## PLANNING CONSULTATION RESPONSE

<b>Application No</b>	2025/1080
<b>Proposal</b>	Change of use of Working Men's Club (Use Class Sui Generis) to 9x supported living dwellinghouses for adults with staff facilities (Use Class C2) including associated alterations to the exterior of the building.
<b>Address</b>	2 Broad Street, Hoyland, Barnsley, S74 9DY
<b>Date of Consultation Reply</b>	27.02.2026
<b>Consultee</b>	Highways Development Control

Proposed Basement Floor

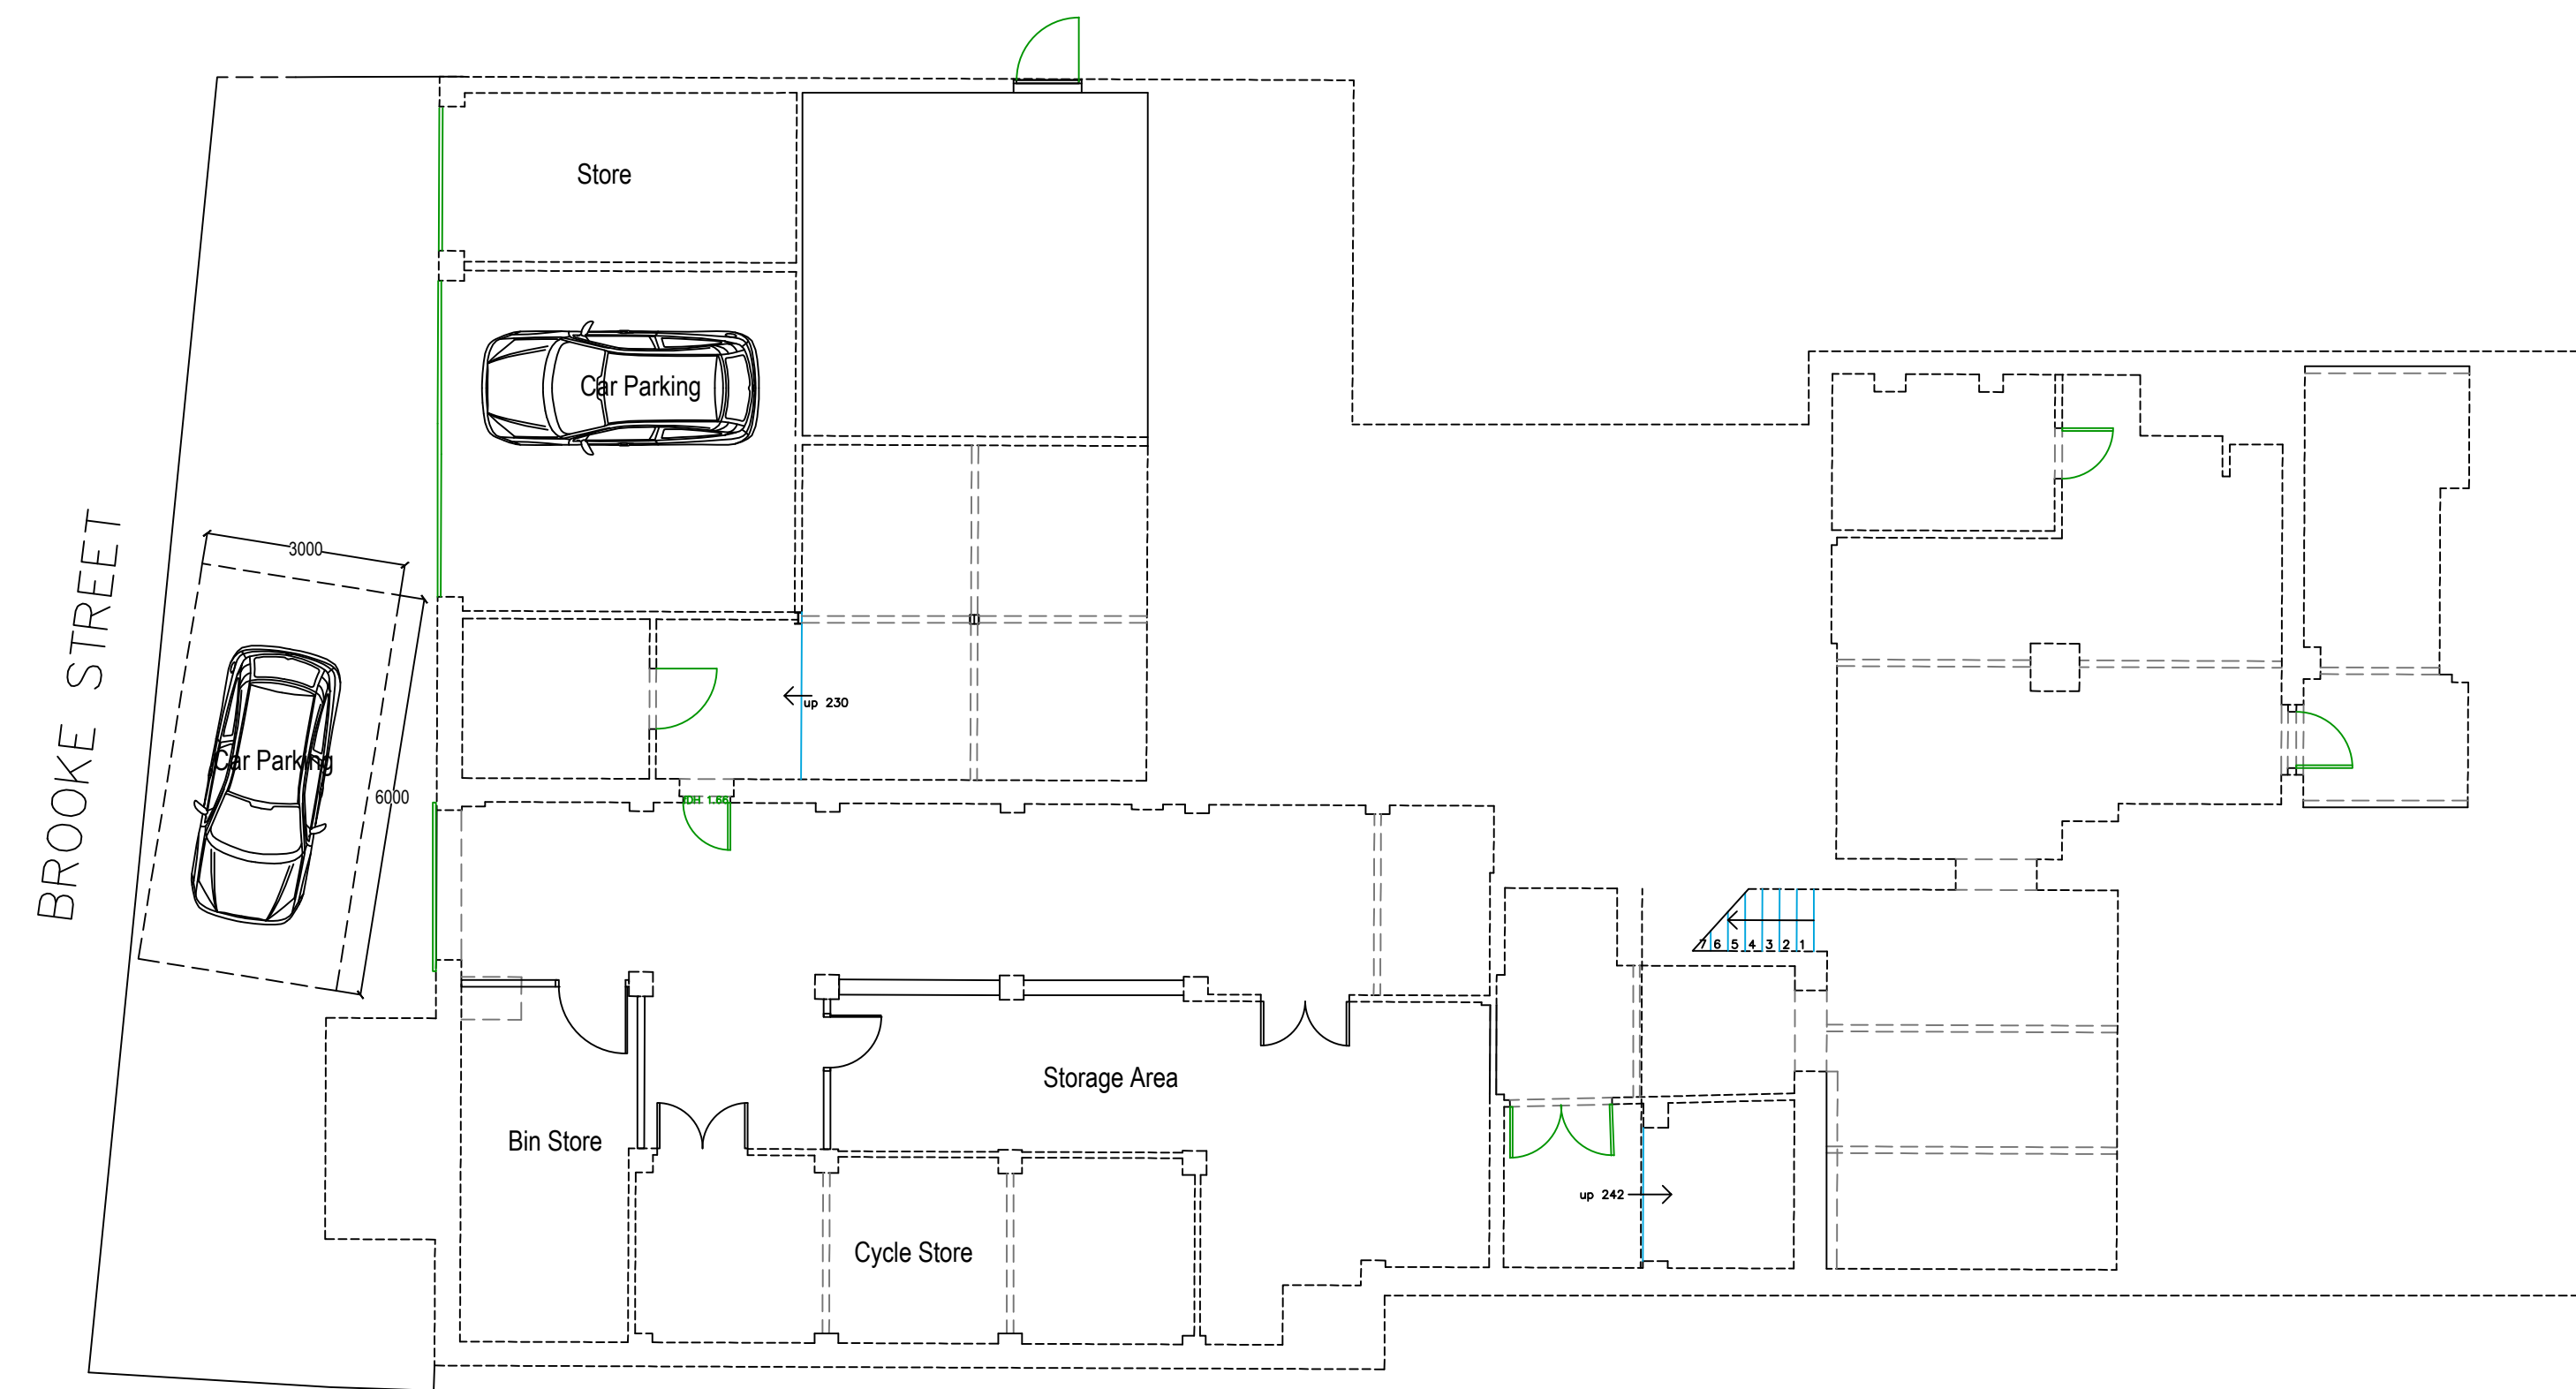
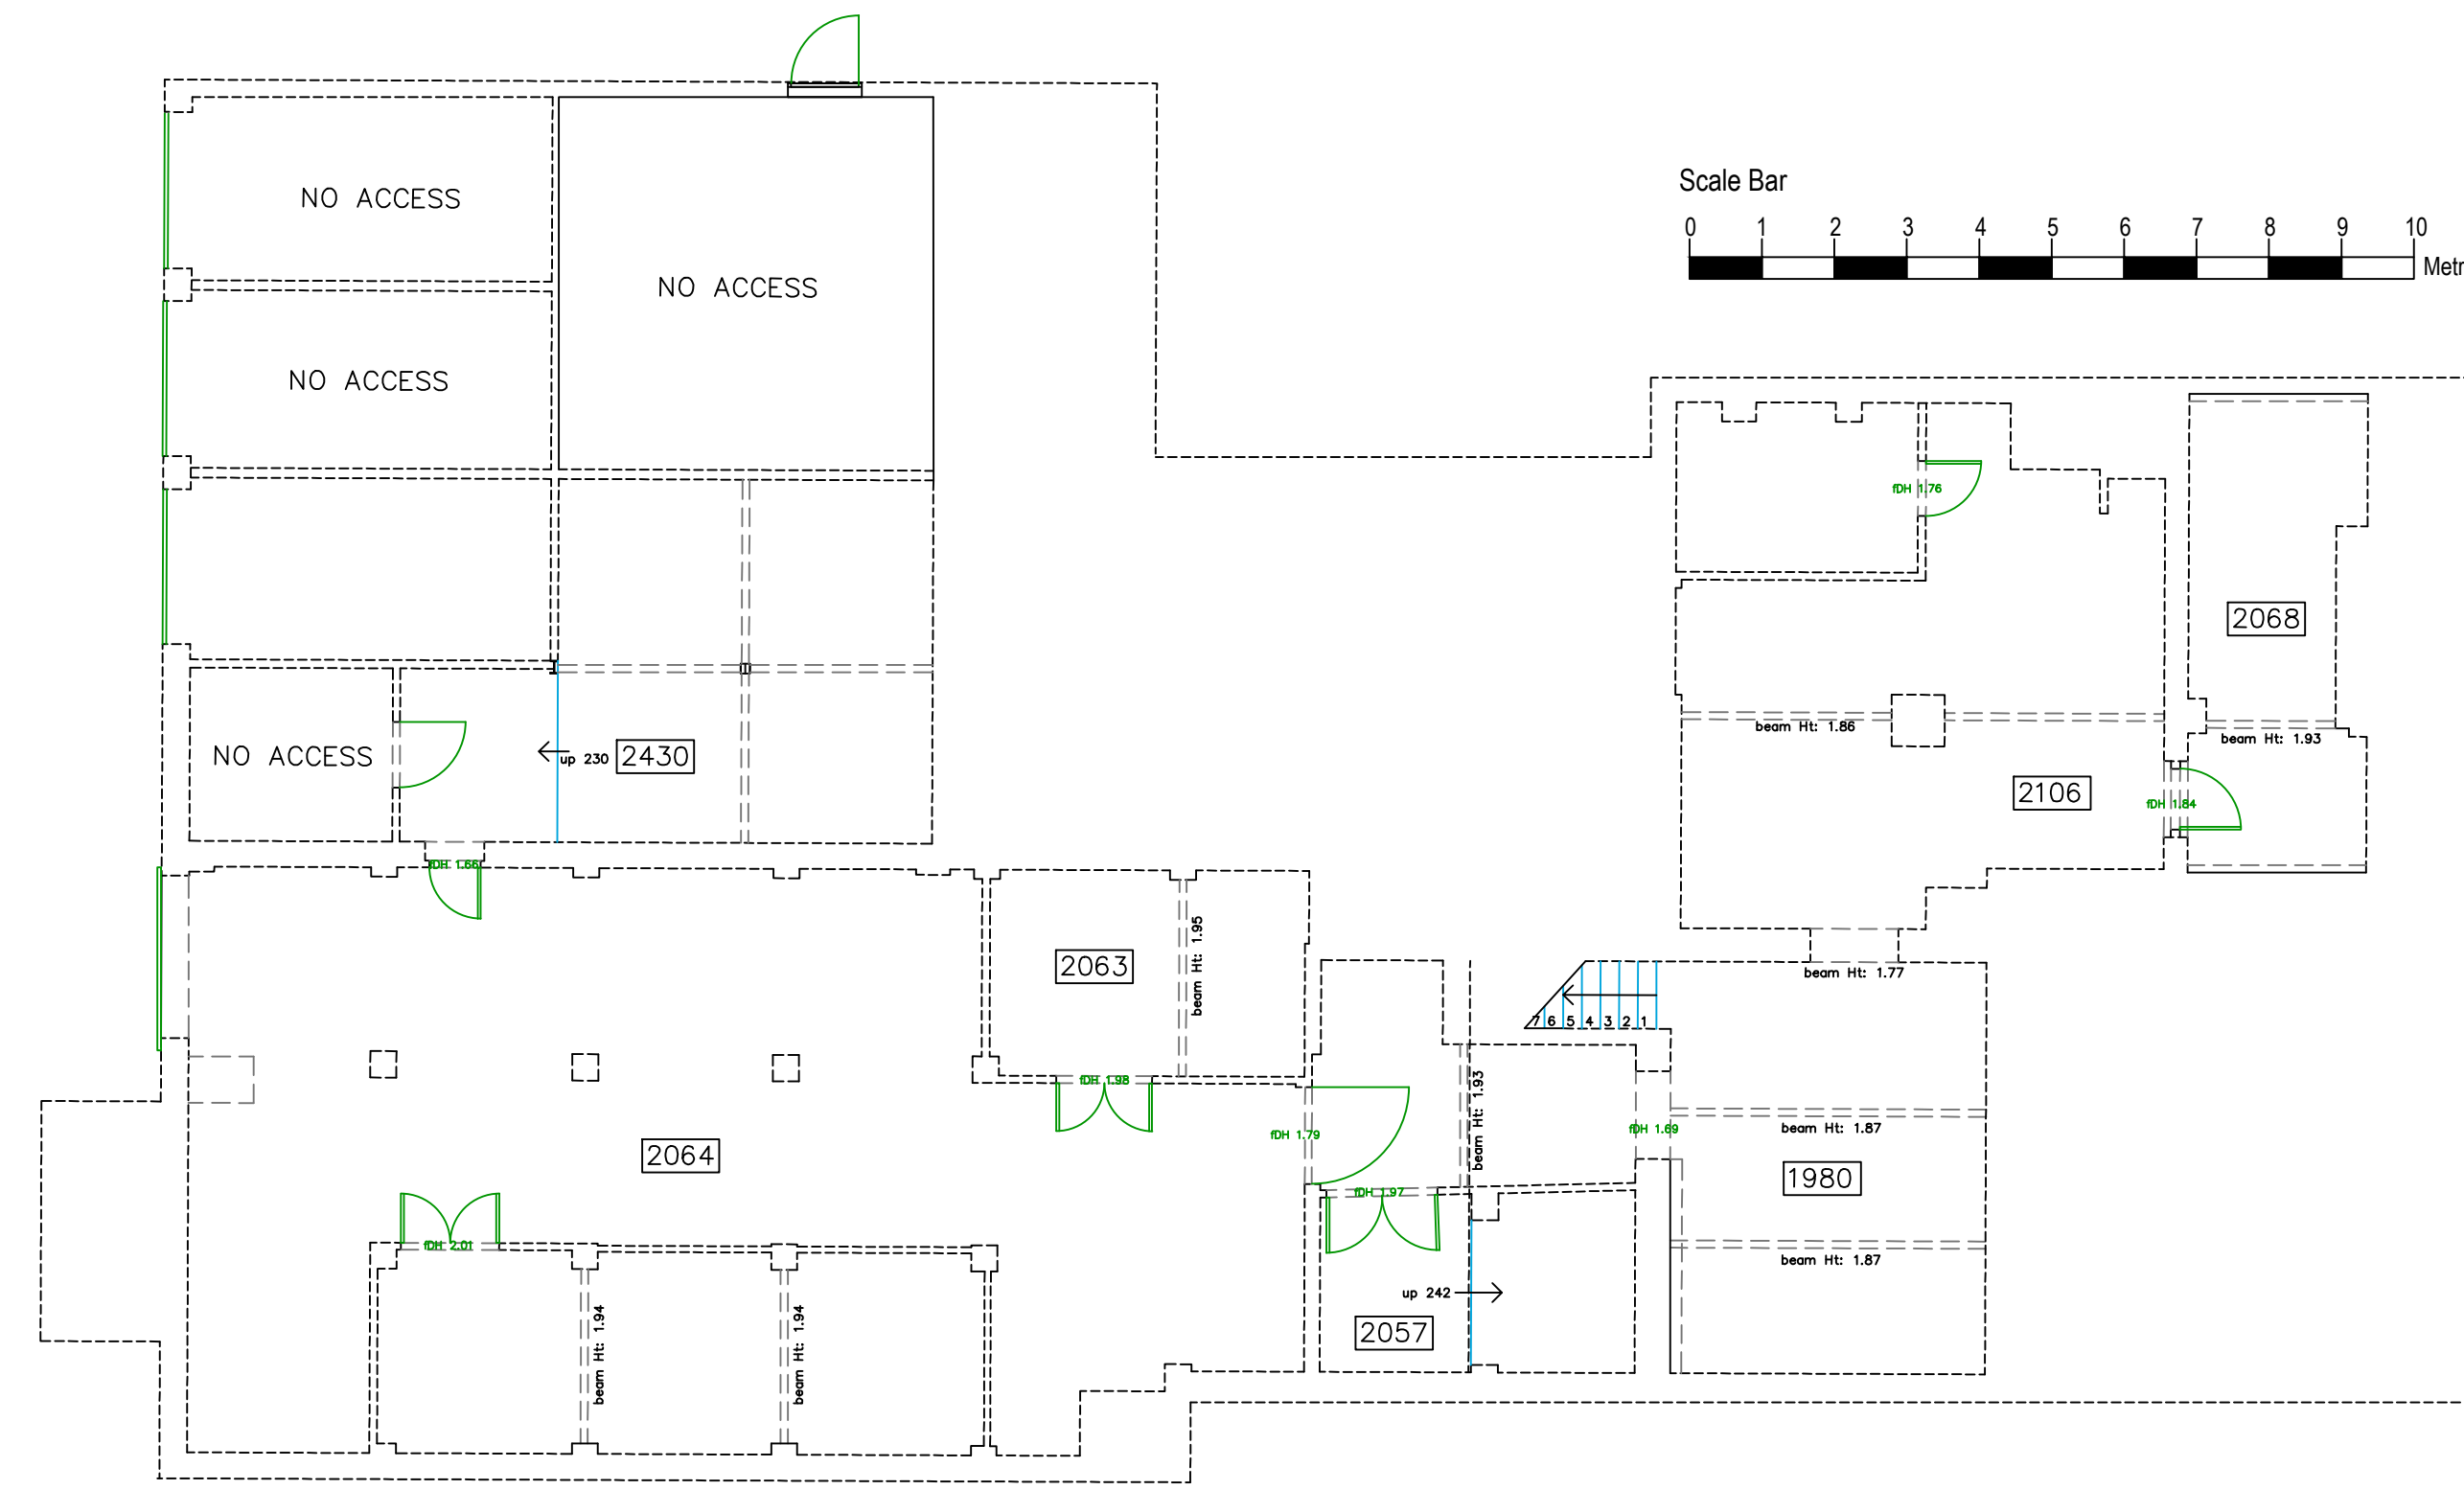
I am somewhat surprised that the applicant has returned with a revised proposal which now demonstrates a reduction in off-street parking provision compared to that previously submitted. The supporting information provided does not give sufficient clarity in respect of staffing levels, shift patterns, and associated movements to enable a robust assessment of whether the proposed parking provision is adequate. While it is acknowledged that some staff may be recruited locally, and therefore may not travel by private car, this cannot be relied upon as a material assumption when assessing parking demand.

Further concern is raised regarding the reliance on garage parking, which introduces additional operational constraints. These include access arrangements to a locked garage, the practicality of manoeuvring within a constrained space, and the potential for conflict during staff shift changeovers, all of which may deter effective use of the spaces in practice.
